# V1Construction Drawings.pdf Markup Summary

SIGNAL FACE DETAILS

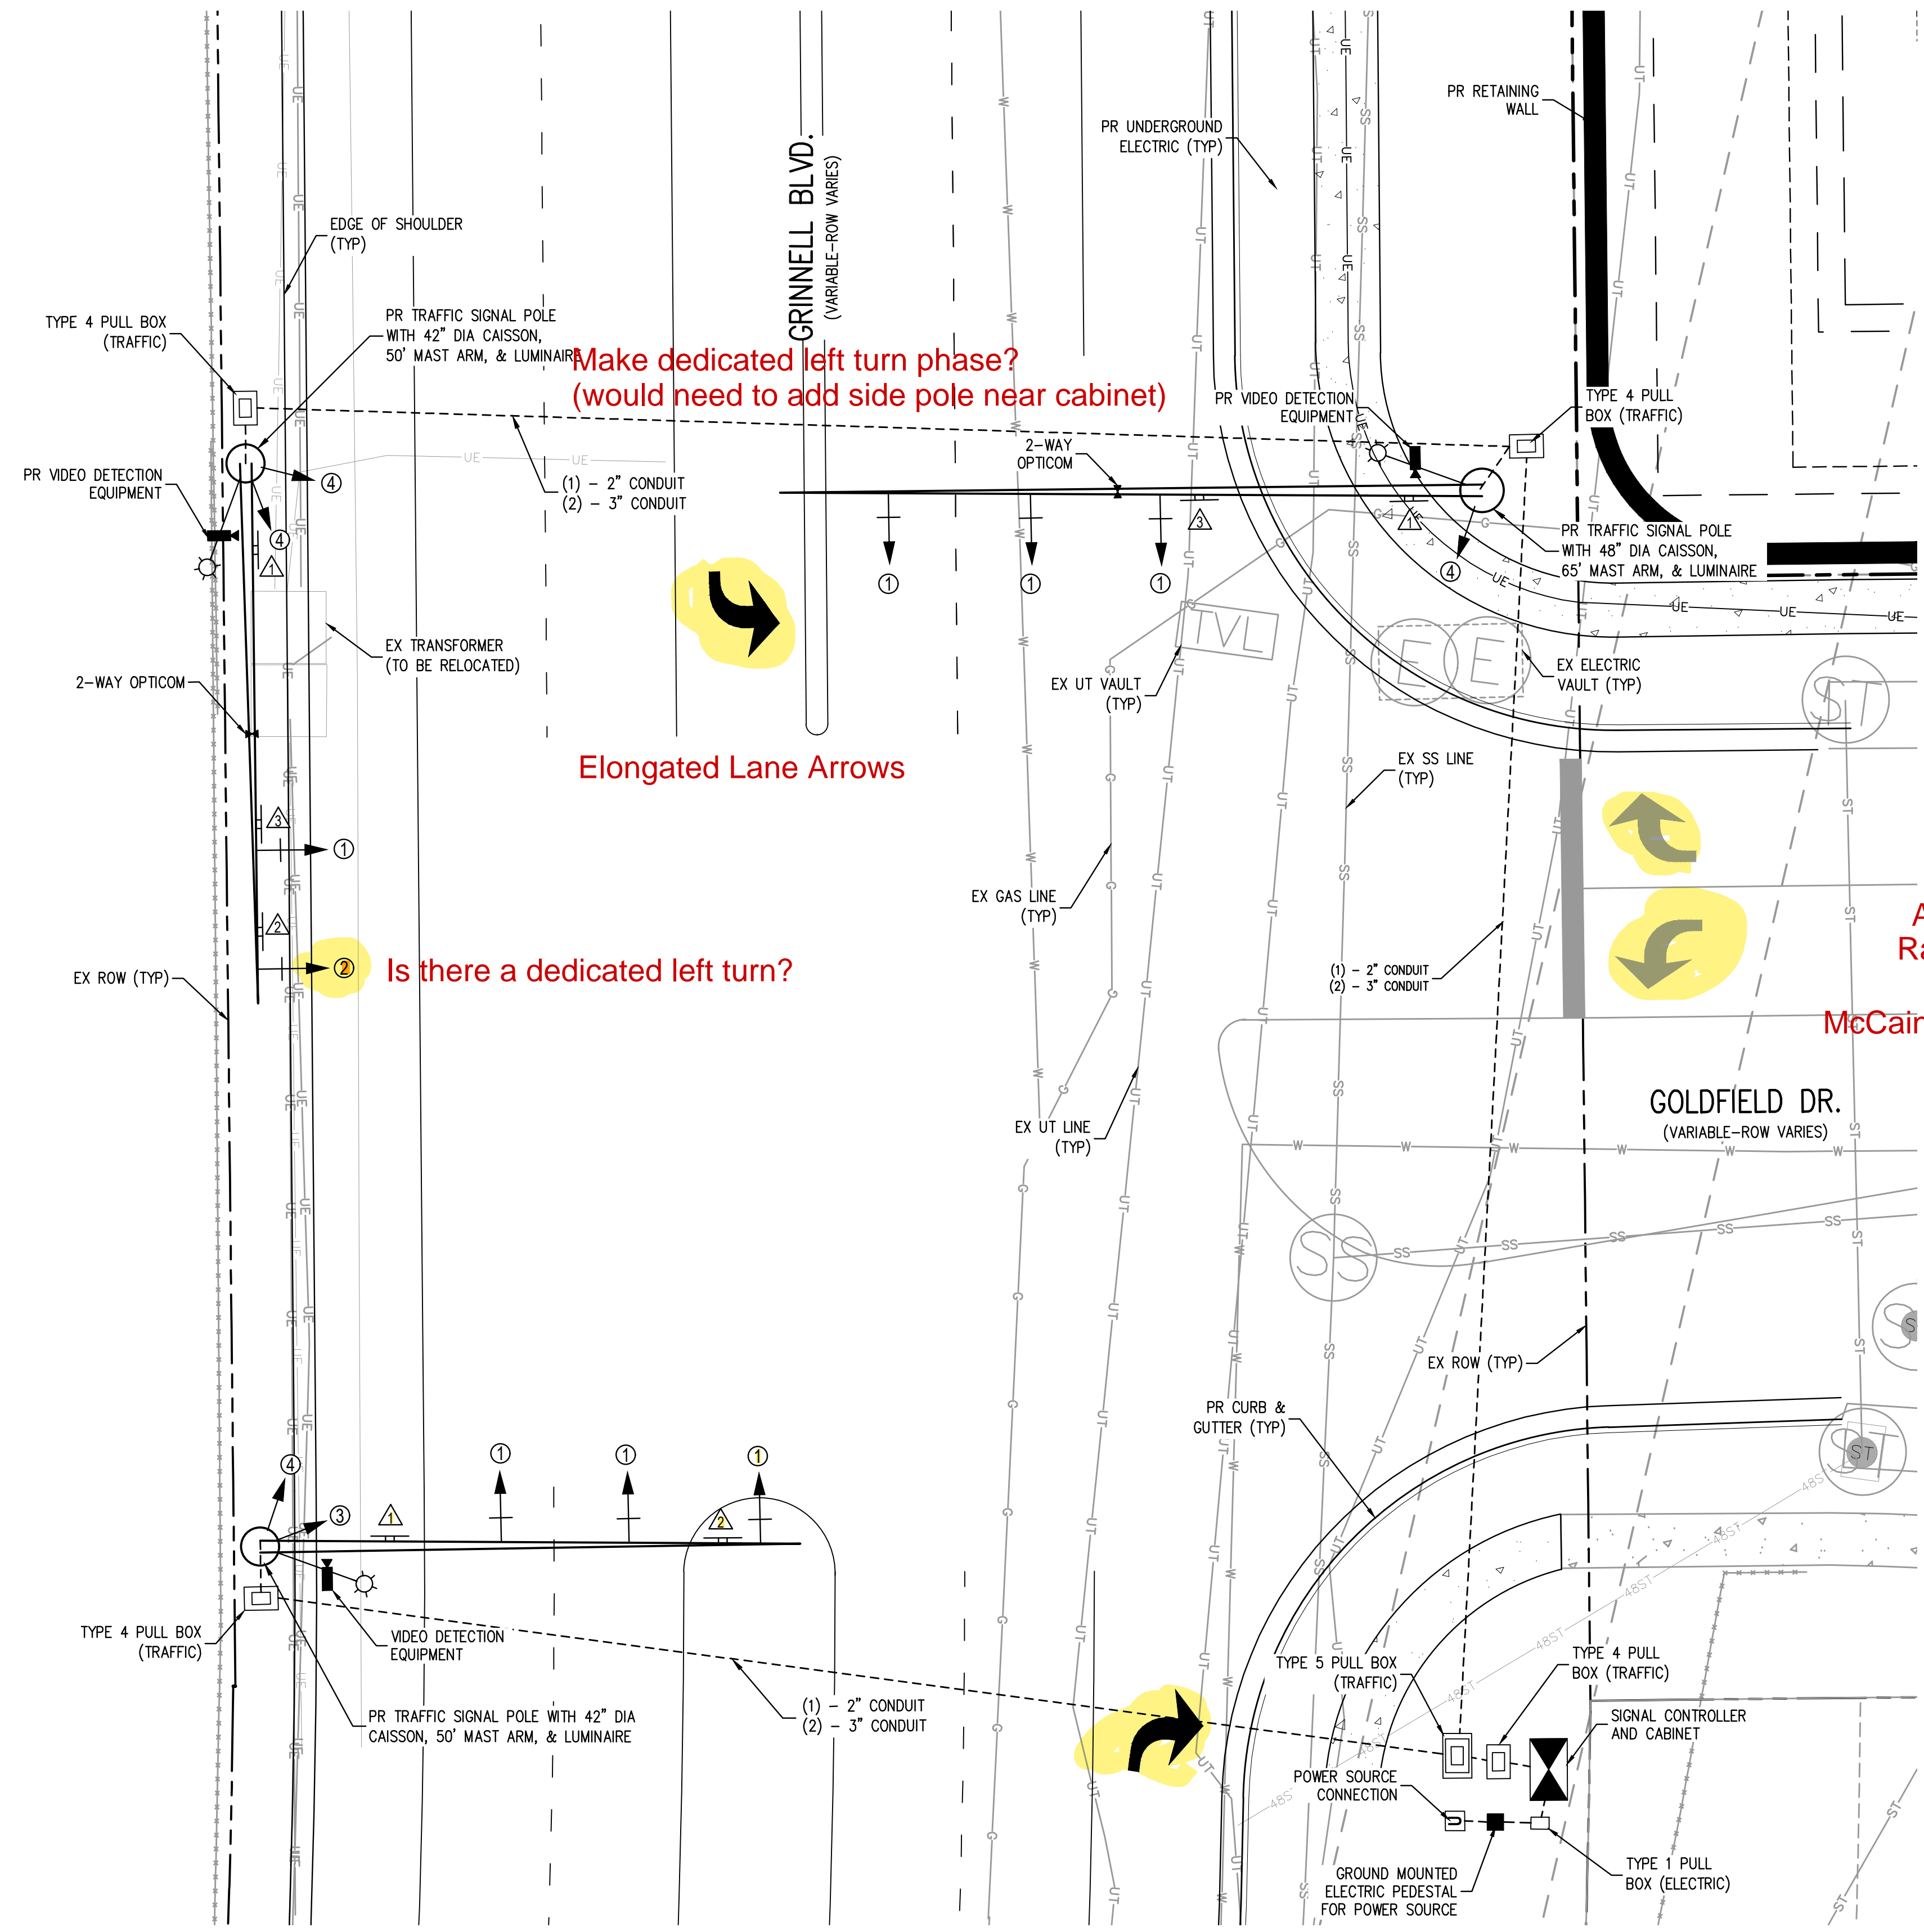
Show pedestrian ramps

Verify with traffic engineer but this should be revised to signal face #2 since there is a southbound left turn.

Staff will verify with Highways if this should be a 4-section vertical head to include a flashing yellow arrow.

provide pedestrian ramp

Revise to (2)-2" and (3)-3"

Verify with traffic engineer if this signal head is necessary. This does not seem to be needed.
